Engineering Review
03/25/2021 4:00:31 PM
dsd
JeffRice@elpaso.co.com
(719) 520-7877
EPC Planning & Community Development Department

WATERMARK AT AKERS GRADING EROSION CONTROL PLAN

TRACT DD, HANNAH RIDGE AT FEATHERGRASS FILING NO. 1, AS AMENDED SECTION 32, TOWNSHIP 13 SOUTH, RANGE 65 WEST OF THE 6TH P.M., CITY OF COLORADO SPRINGS, COUNTY OF EL PASO, STATE OF COLORADO

PCD Project Number: PPR-21-17

WATERMARK AT AKERS  
EL PASO COUNTY, COLORADO  
GRADING AND EROSION CONTROL PLANS  
COVER SHEET

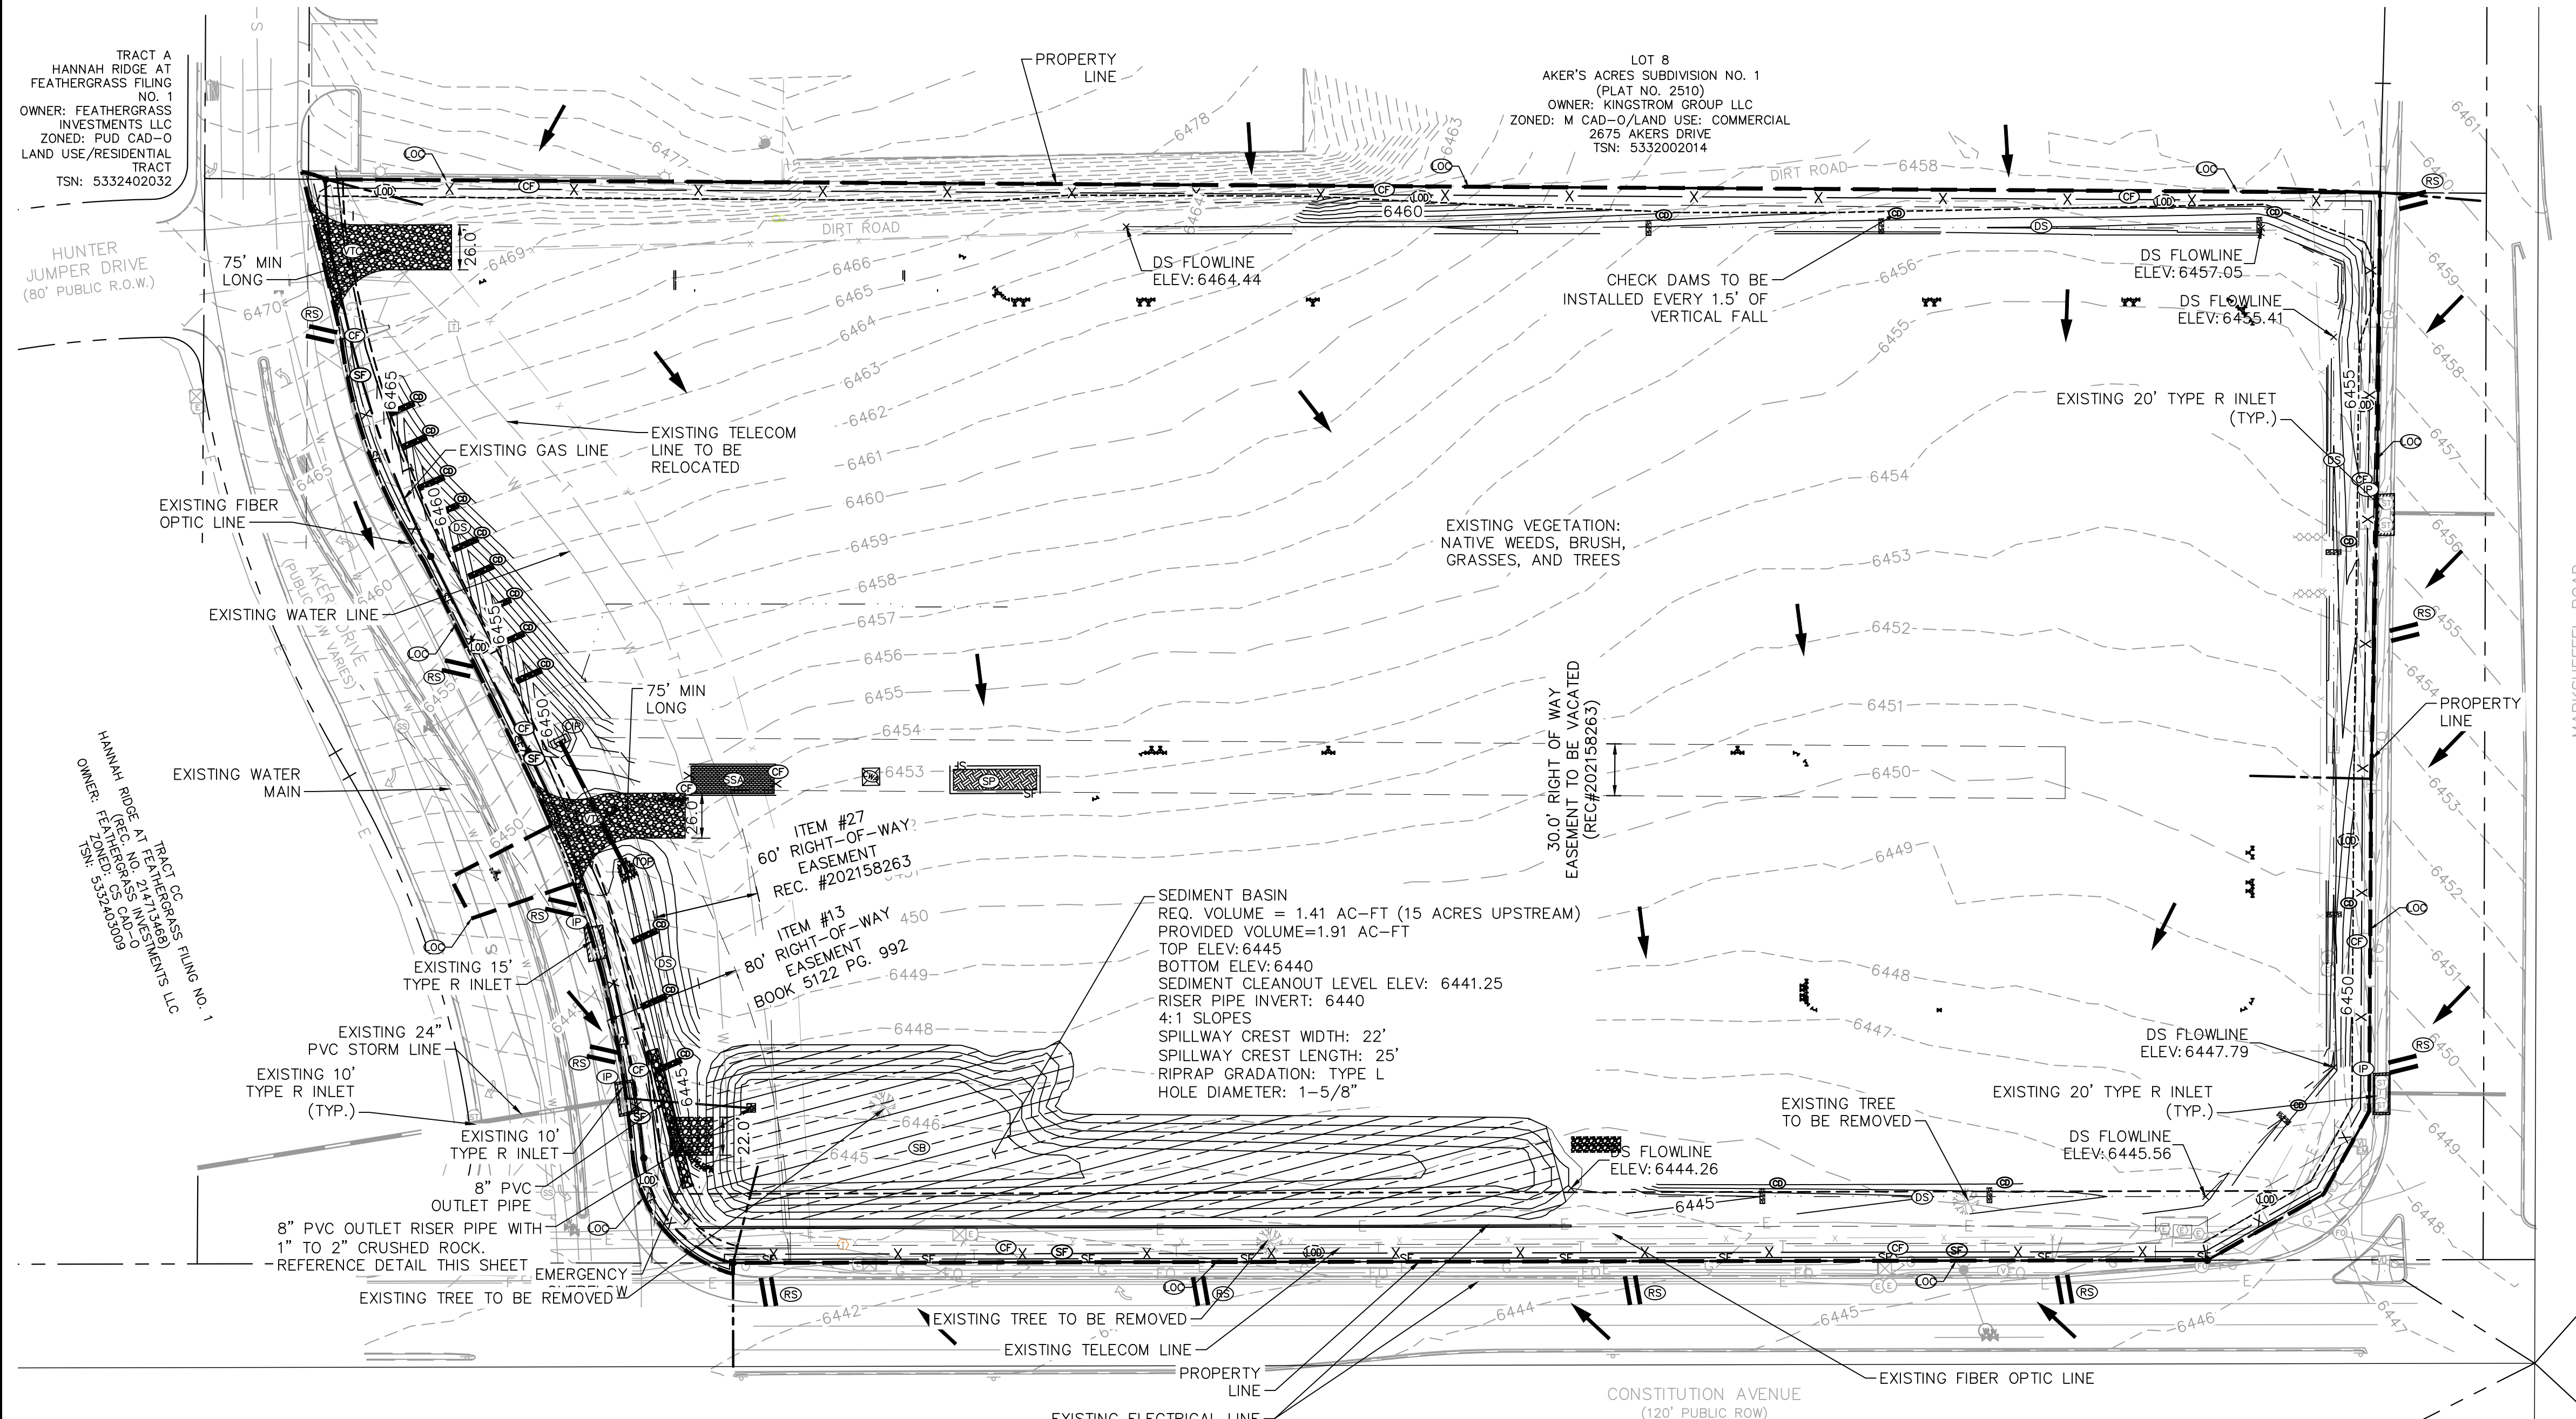
Please use signature blocks for a Standalone GEC Plan (See GEC Checklist items ff and hh)

SWMP states that the soils report was prepared by Kumar and Associates, dated 9/20/2020. Please confirm.

PROJECT NO. 096302009  
 SHEET C2.1

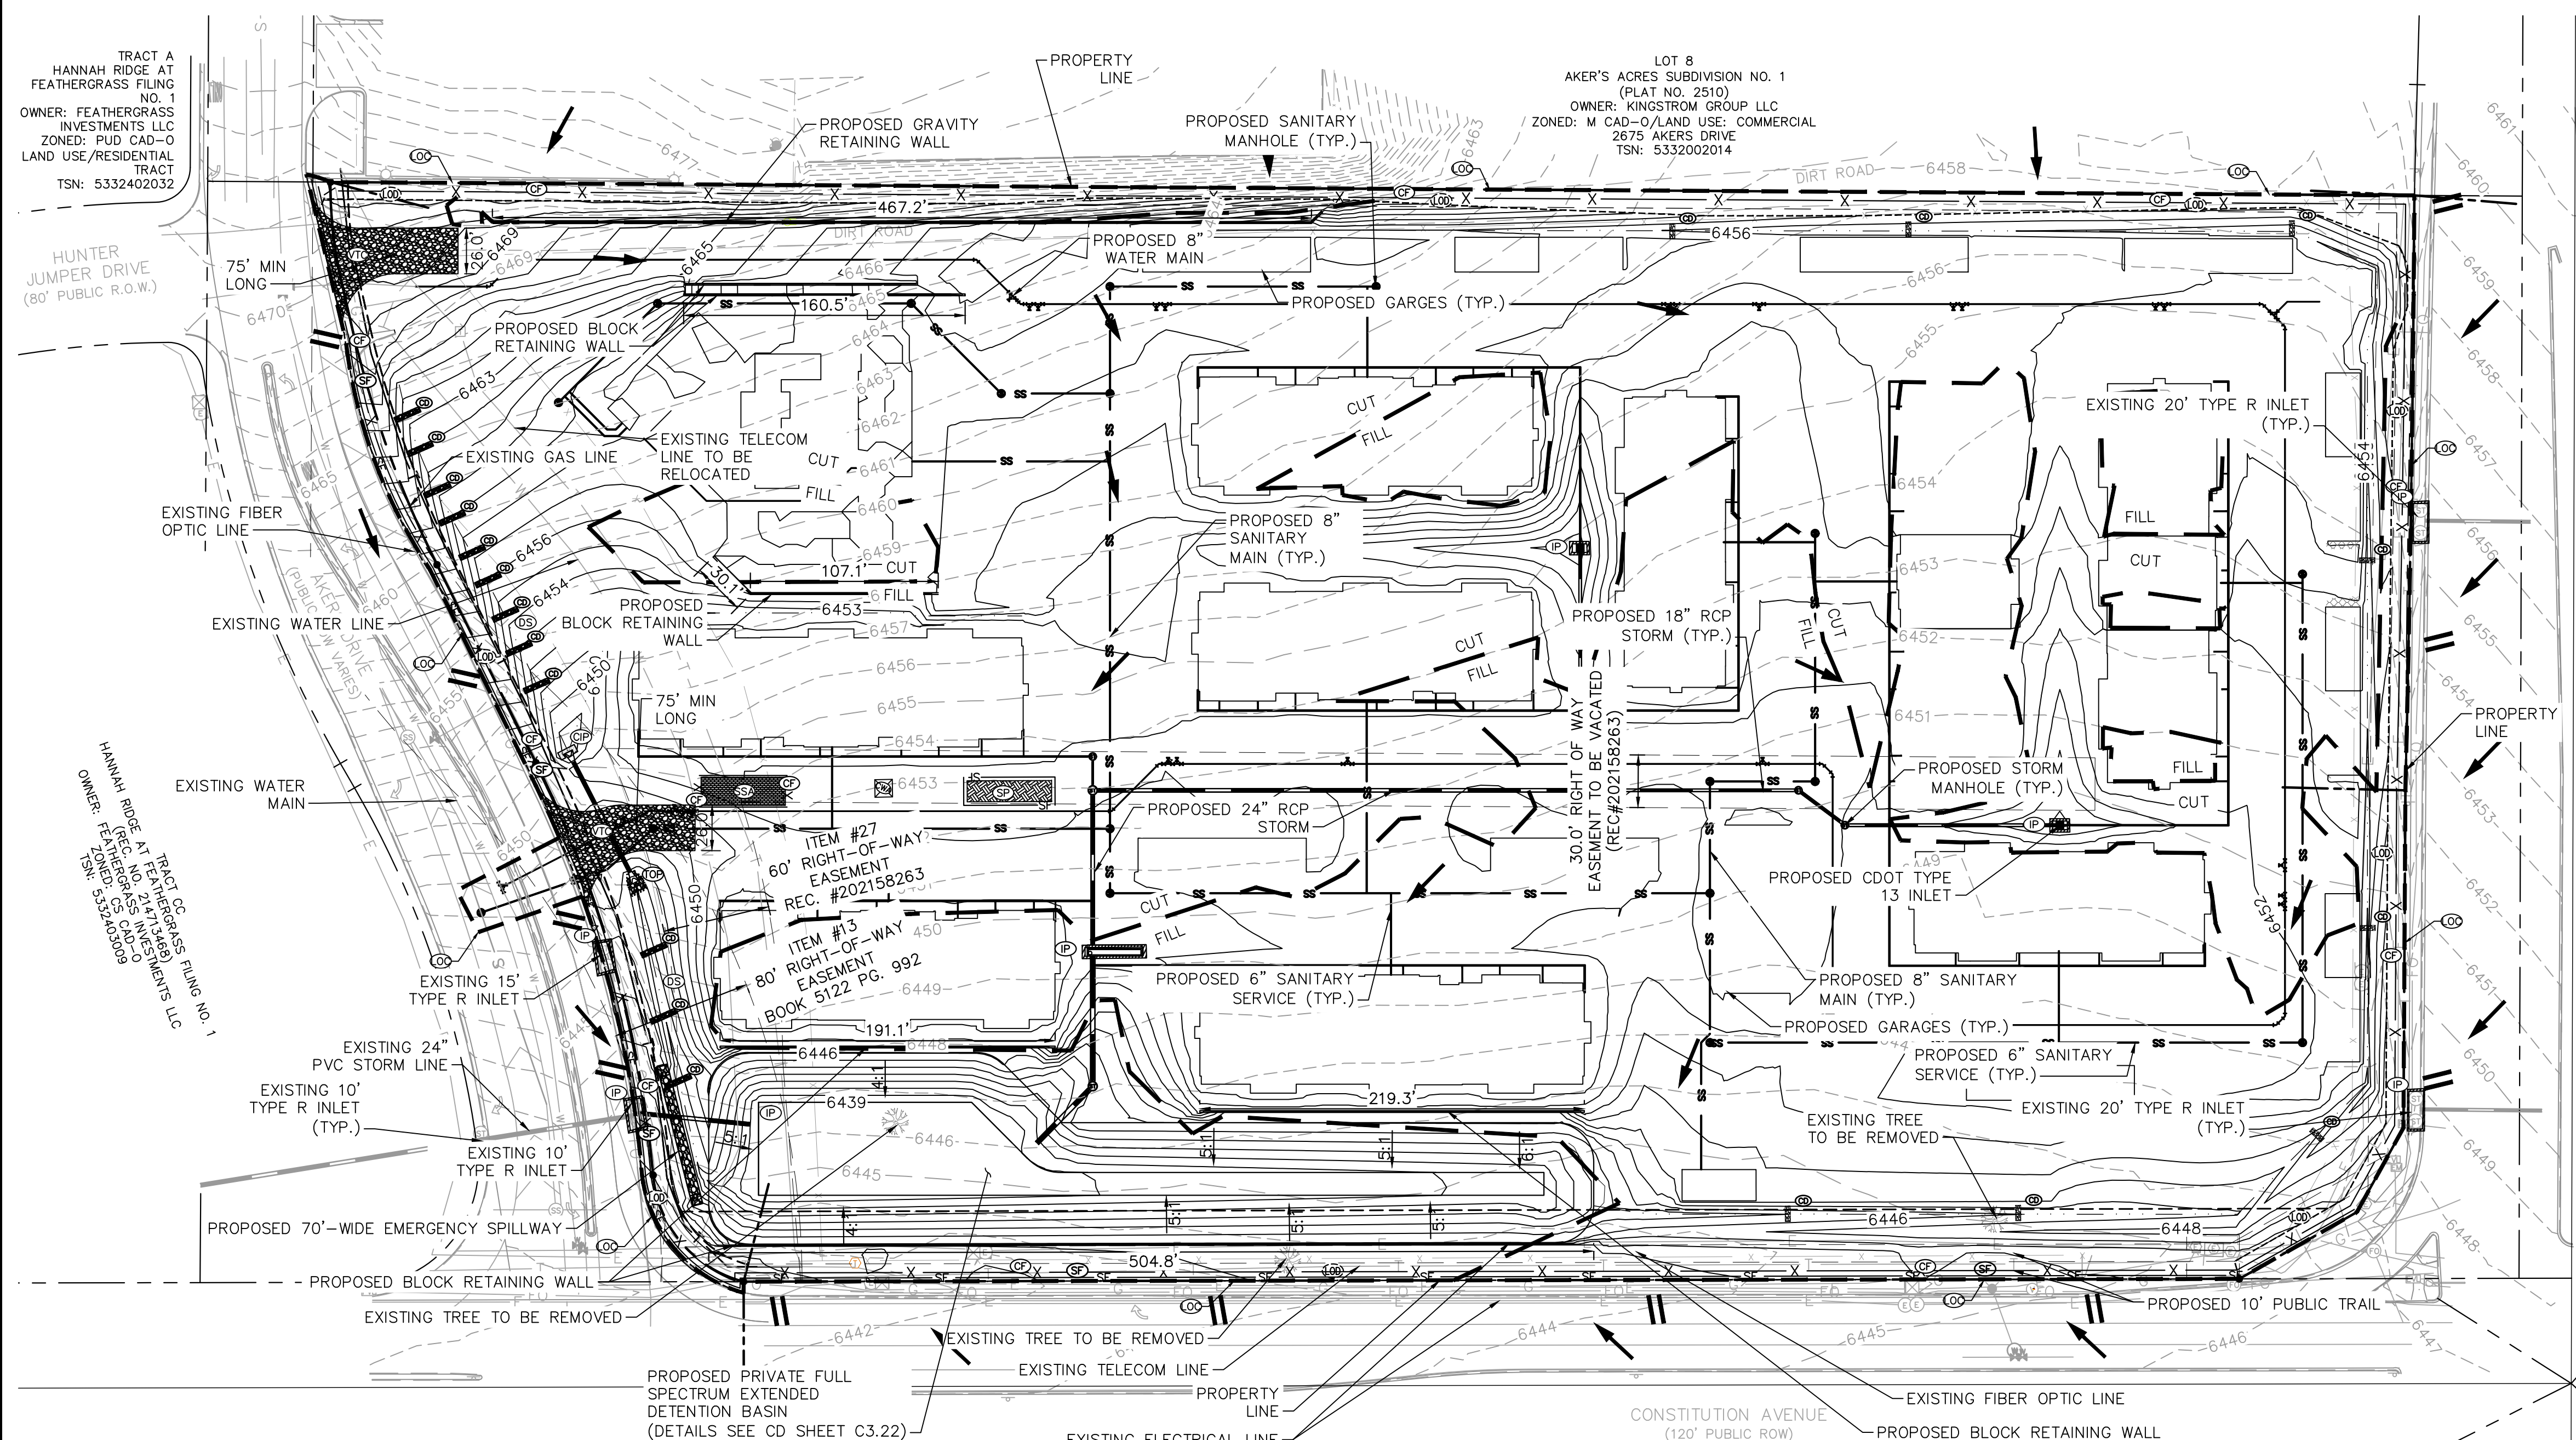
If existing trees are to be removed, please state as such

add a note stating that the pond details are in the CDs Sheet C3.22
